PINS Reference TR050006 - Northampton Gateway RFI

IP REF. SP074 - South Northamptonshire Council SNC ref 20190312/wr/ish5

**South Northamptonshire Council – Written Submission pursuant to
ISH 5 – Draft DCO document 3.1D**

Drawing Title		WORKS PLANS KEY PLAN	
Scale	1:15,000	Drawn	P. Goodyear
Size	A1	Reviewed	S. Hilditch
Regulation	5(2) (j)	Document	2.2
Drawing Status		SUBMISSION	
Drawing No.		Revision	
NGW-BWB-LSI-XX-DR-C-00160		P12

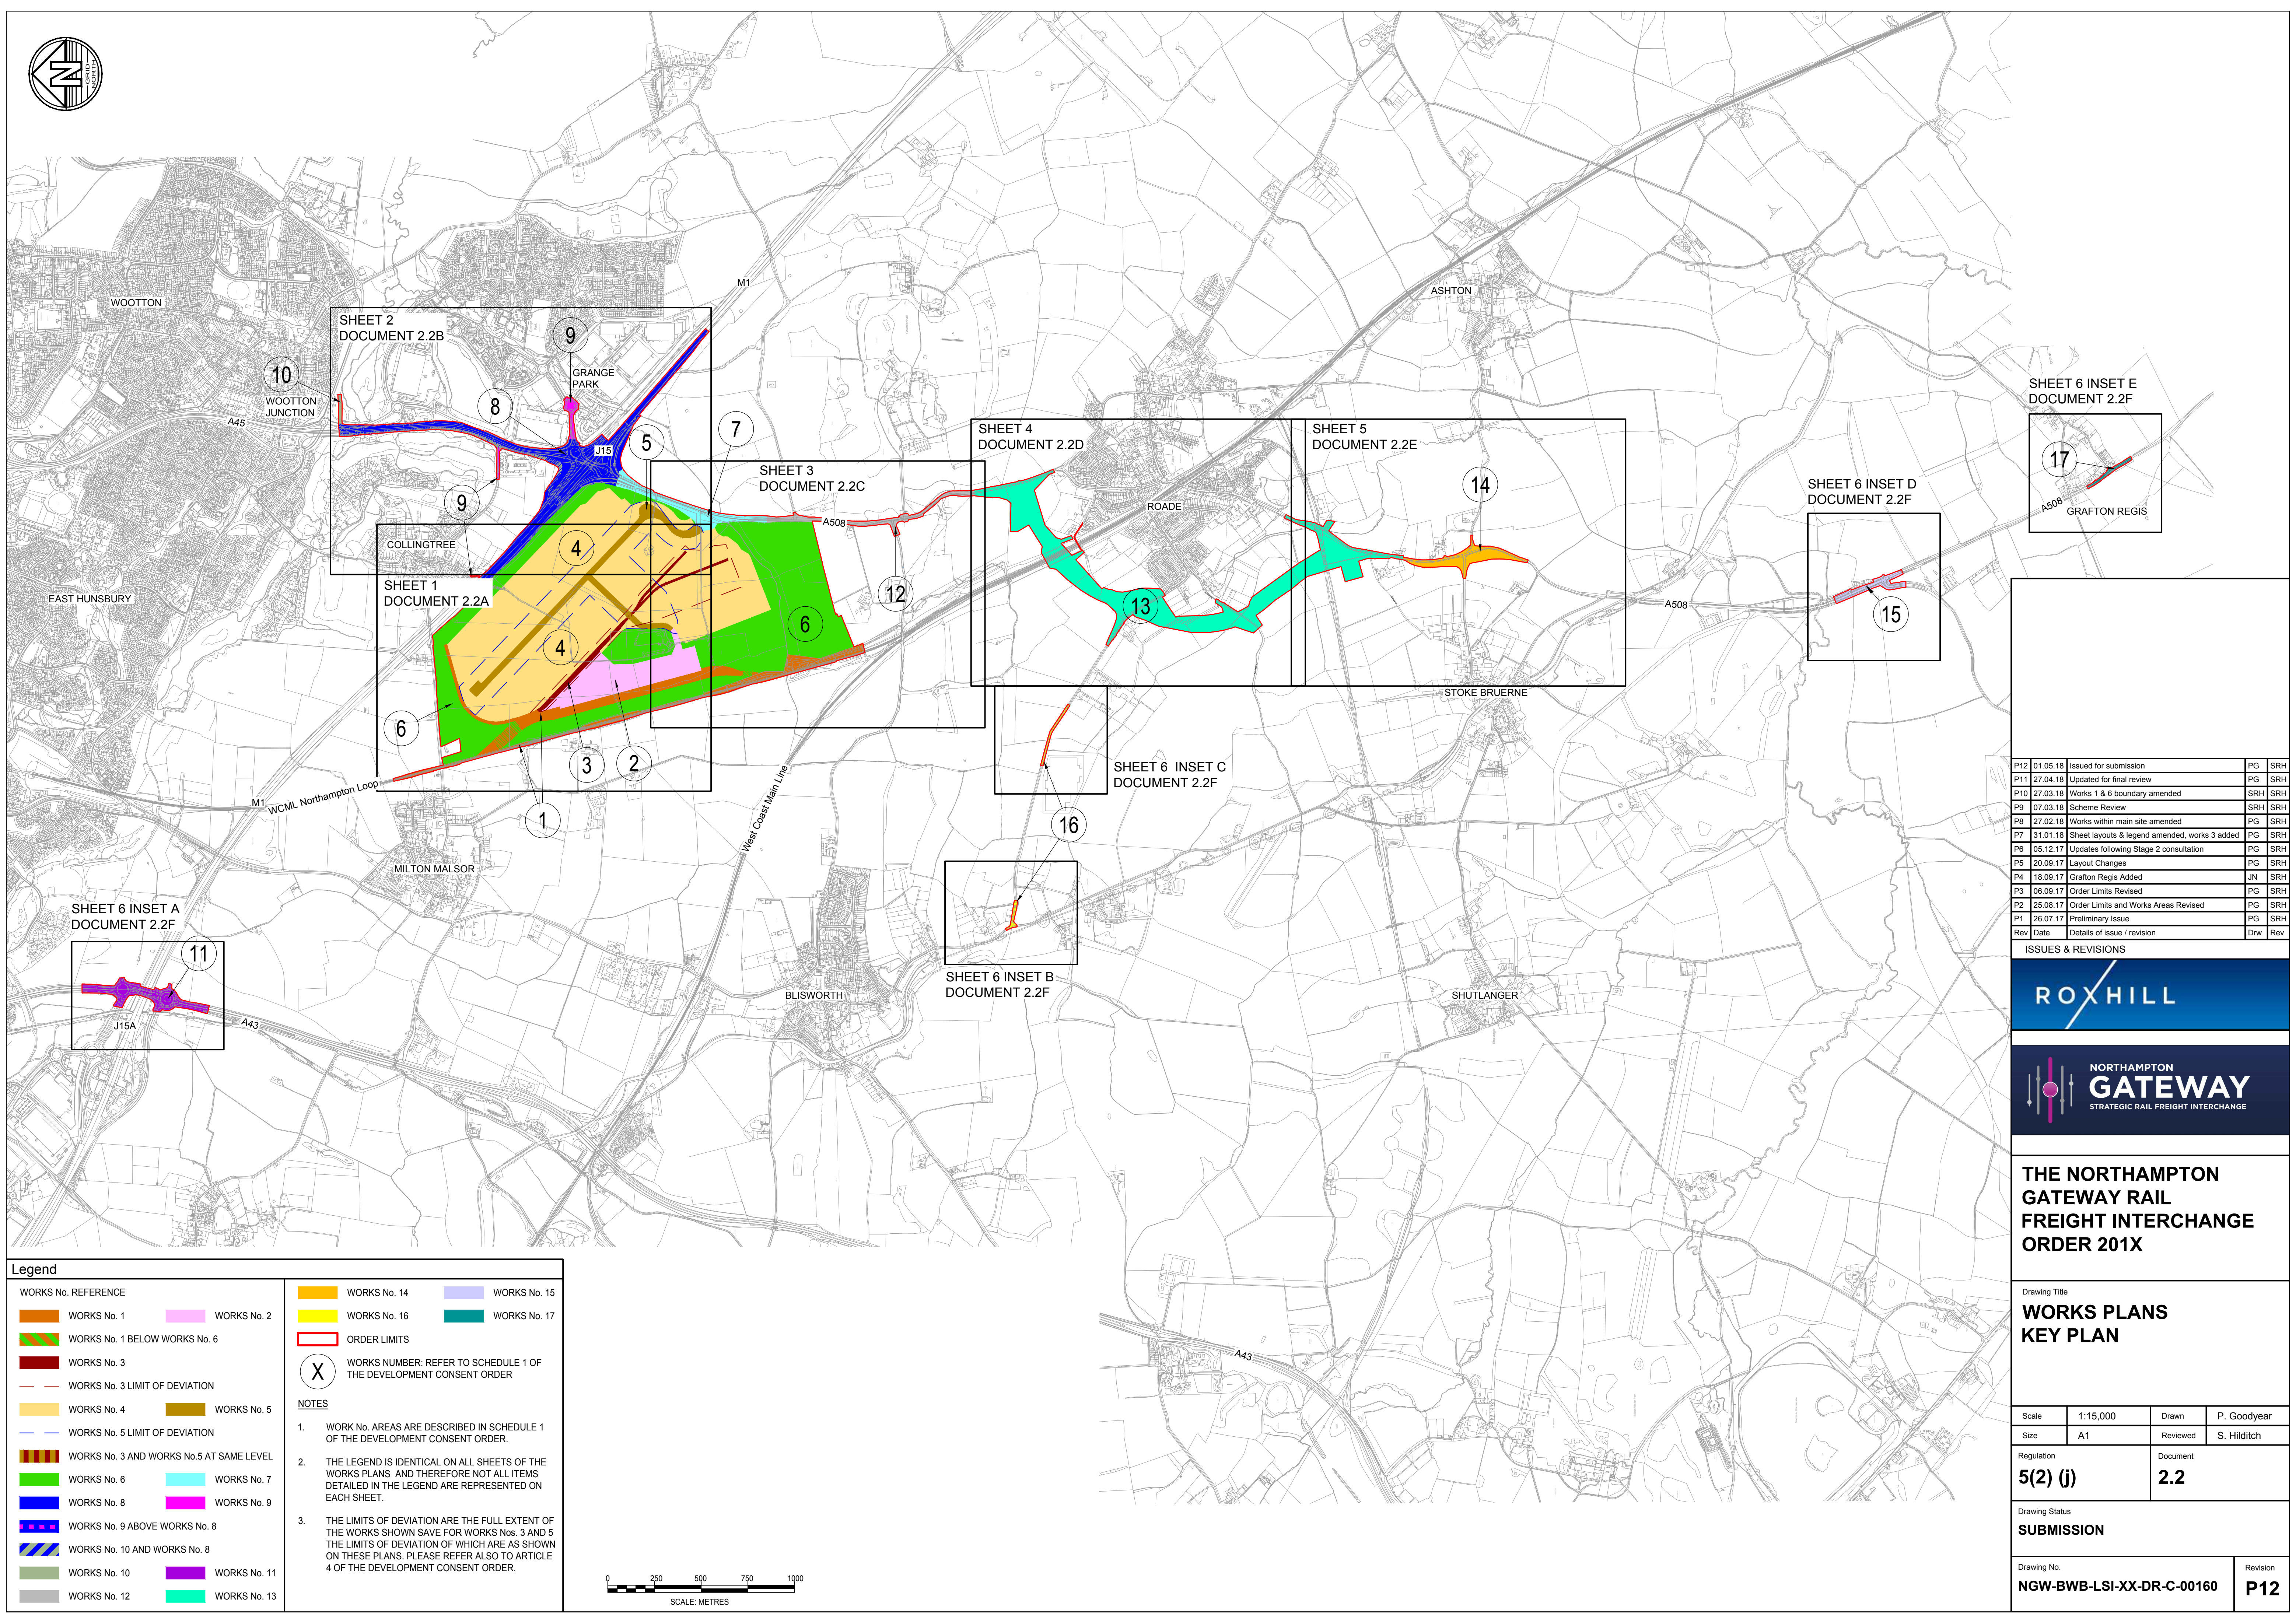
9. This relates to details of permanent advertisements in locations S1 and S2, the display of the advertisements in these locations is identified in Works No.6 (3). The principle of the display of advertisements in these locations is thus currently affirmed by the DCO.

10. Position S2 will be visible from the M1 motorway, the display of advertisements in this location could have adverse impacts for safety on the highway,. The DCO should therefore not permit in principle the display of advertisements in location S2.

11. The Council’s view remains that the display of advertisements in locations S1 and S2 on the site should remain subject to the control regime established by The Town and Country Planning (Control of Advertisements) (England) Regulations 2007. No compelling argument has been put forward to justify the disapplication of the advertisement regulations.

12. The works identified in Schedule 1 Part 1 as Works No.6 (3) should therefore be removed from the DCO and requirement 8(2)n deleted.
13. **Requirement 8(2)** This includes no reference to approval of details of water supplies to be provided for firefighting purposes within the site. It is not
